WEST SUSSEX COUNTY COUNCIL CONSULTATION

TO:	Arun District Council FAO:David Easton
FROM:	WSCC - Highways Authority
DATE:	19 October 2021
LOCATION:	Oldlands Farm Cottages Steyning Way Bersted PO22 9NN
SUBJECT:	BE/145/21/DOC Approval of details reserved by condition imposed under ref BE/126/19/PL relating to Condition Nos 4 - hard & soft landscaping, 5 - pedestrian link/cycle link, 9 - Travel Plan and 13 - electric vehicle charging.
DATE OF SITE VISIT:	n/a
RECOMMENDATION:	Advice
S106 CONTRIBUTION TOTAL:	n/a

title
S.278 AGREEMENT PLAN

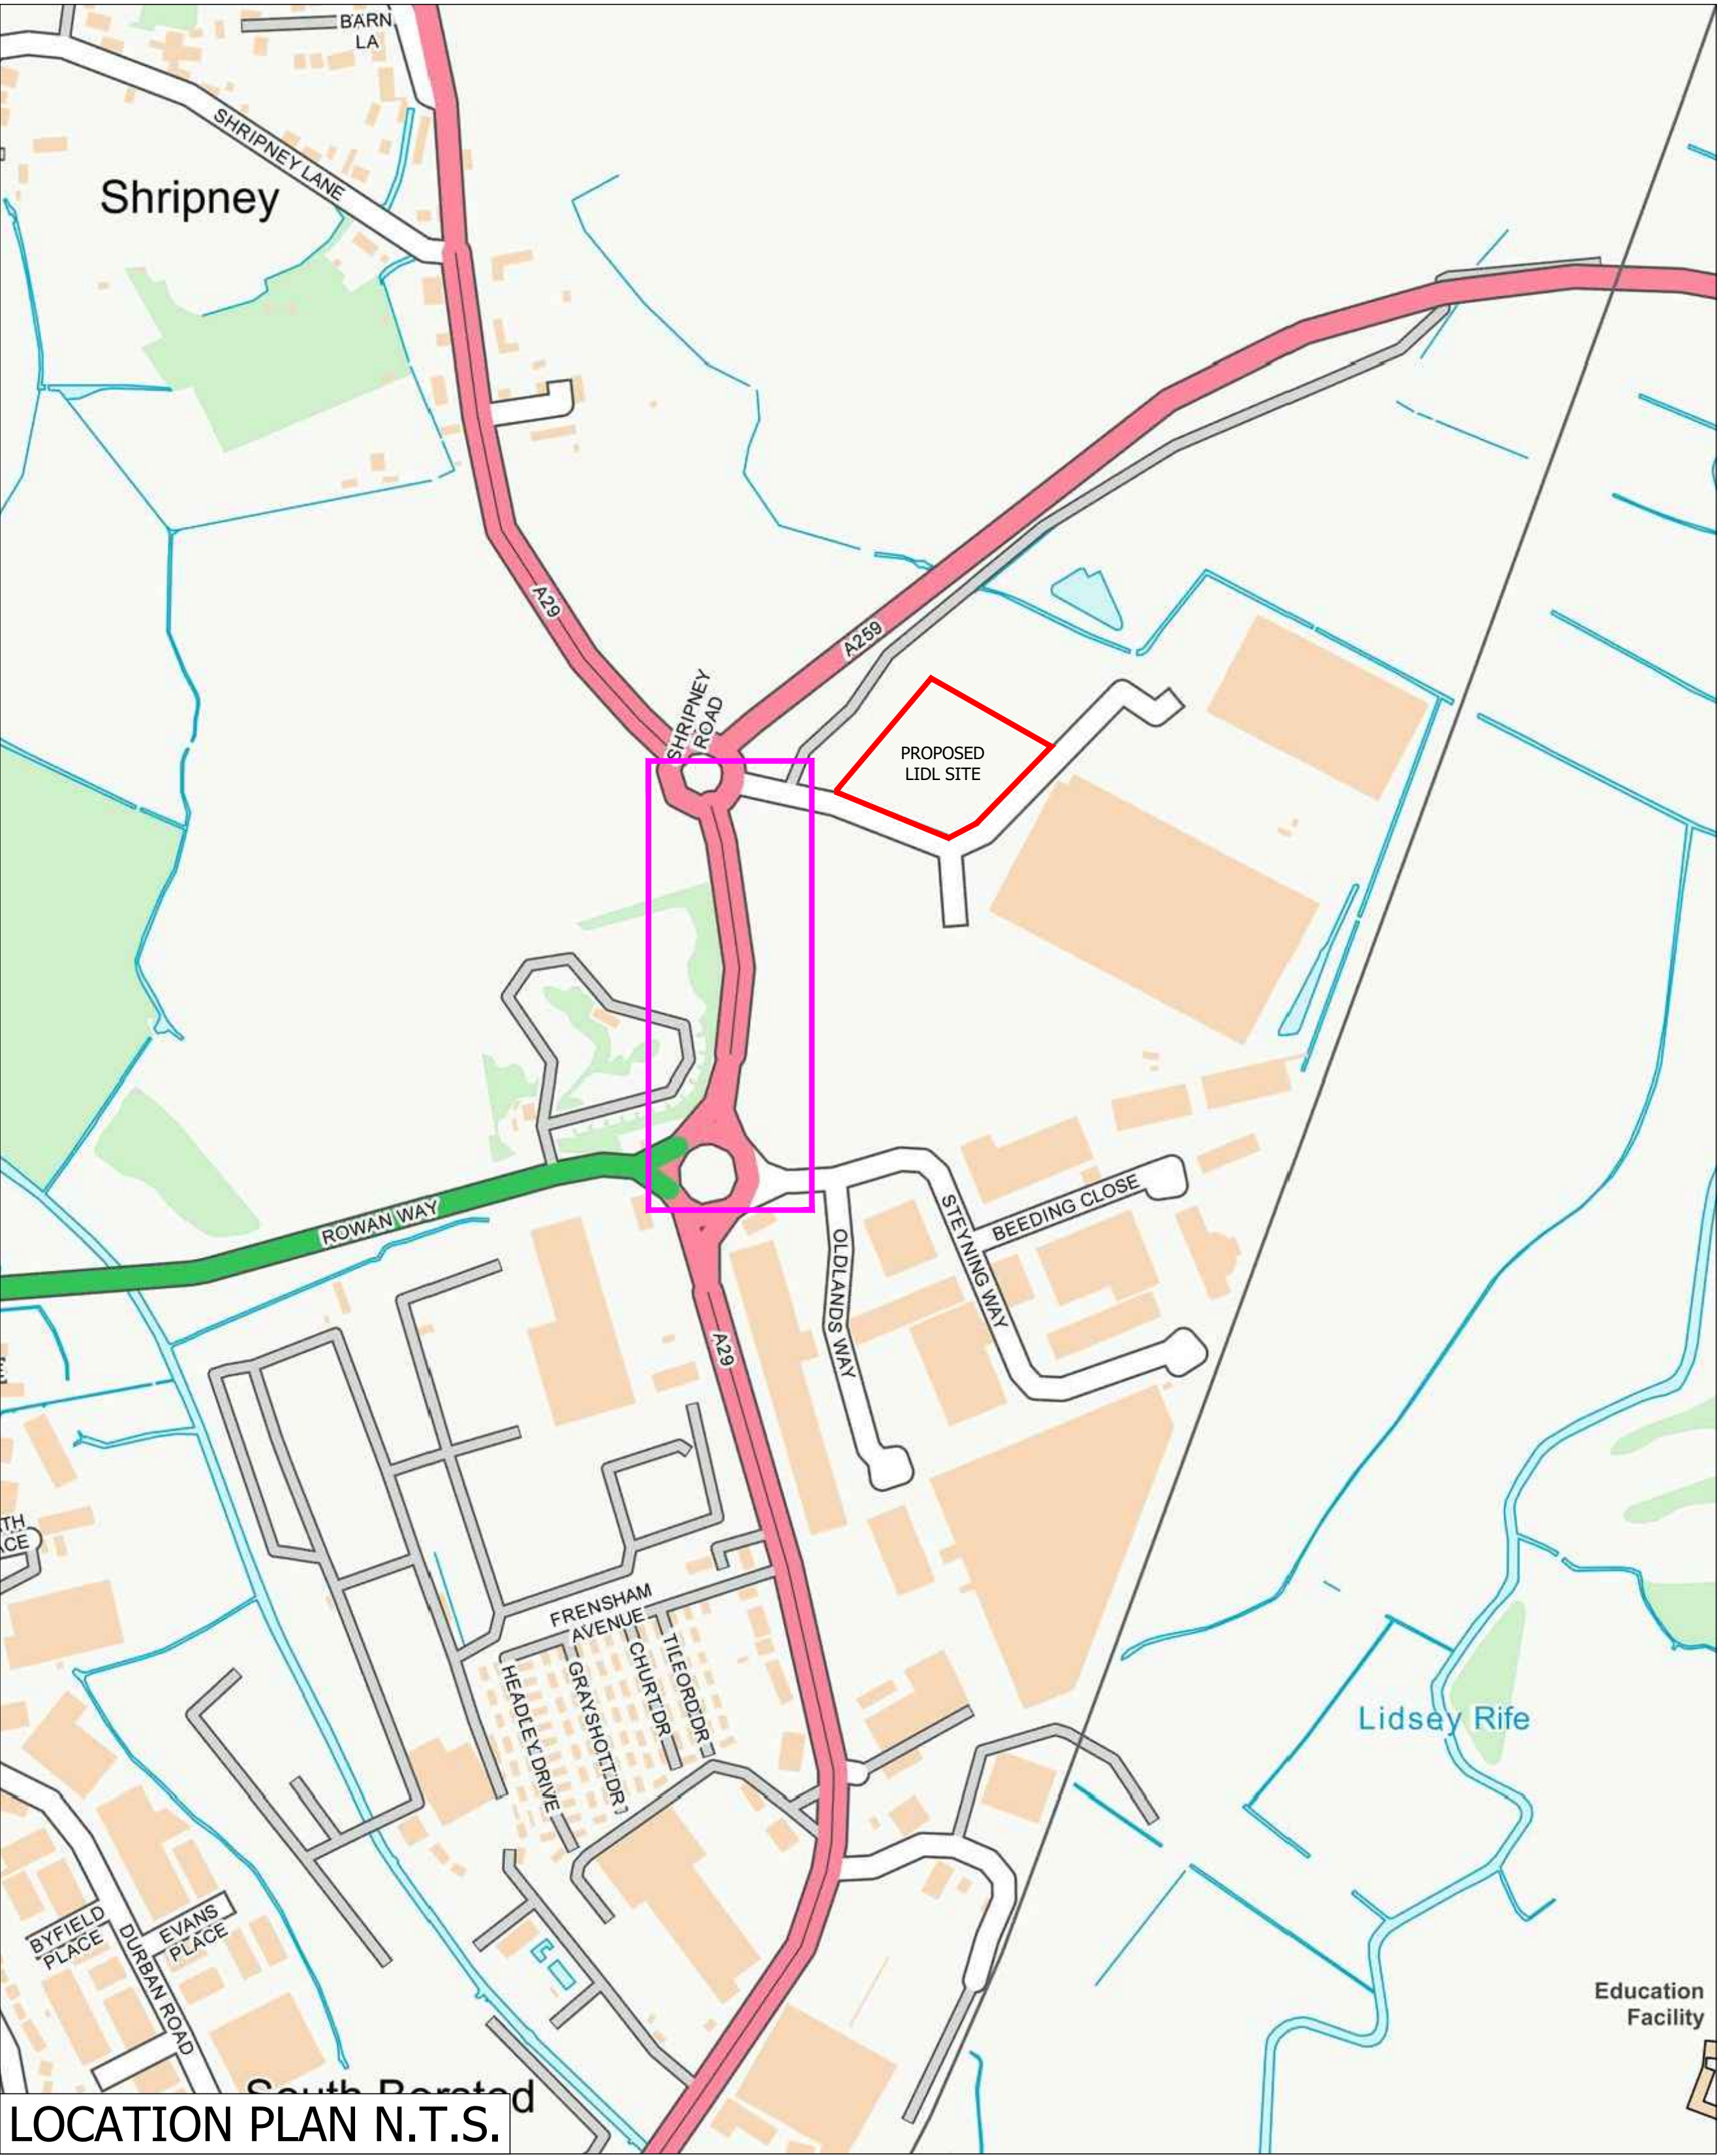
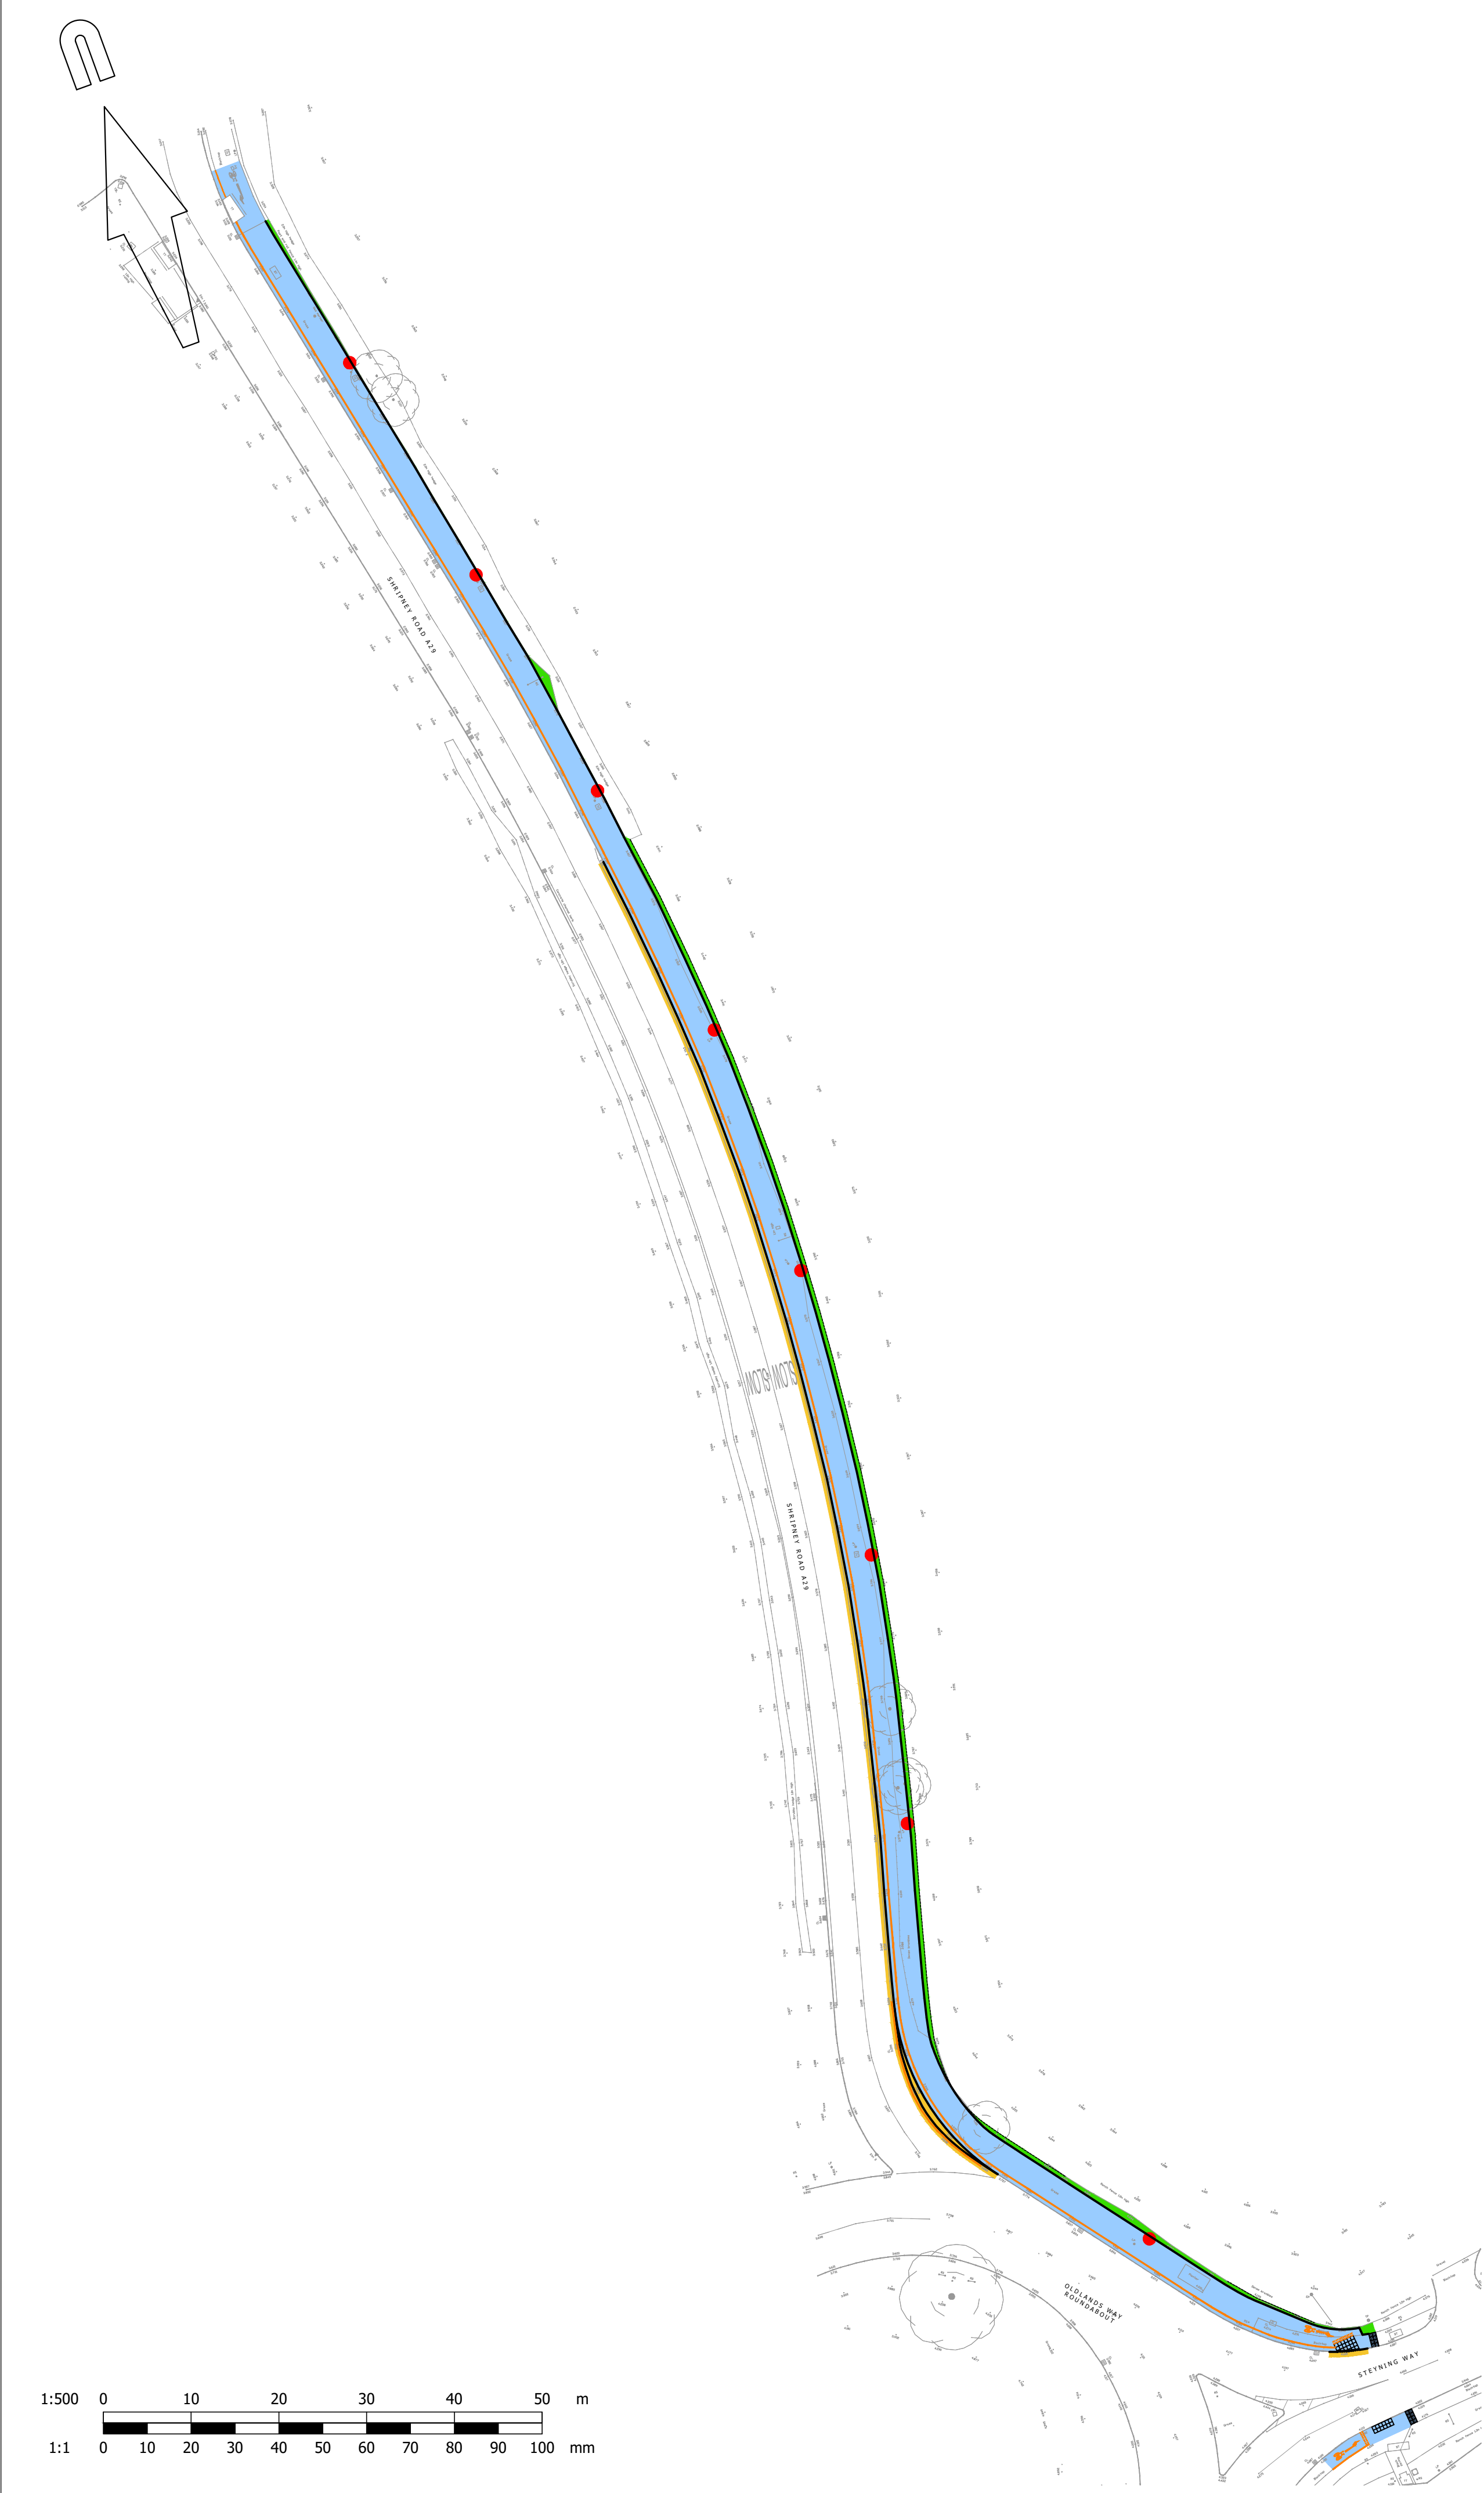
Condition 5-This relates to the pedestrian/cycle route along the A29. This has been demonstrated satisfactorily on the plan provided. However, at the time of writing this is around three quarters complete because the route of the cycleway at the Oldlands Roundabout has come into conflict with an existing HV Electricity cable, which is waiting to be diverted to complete the works. Given the condition states '*implement the works in full*' it is considered that this condition cannot be released at this point. However as the condition does seek a timescale of the works; if an update can be provided and an estimated completion date given we would consider this sufficient information to allow the condition to be discharged.
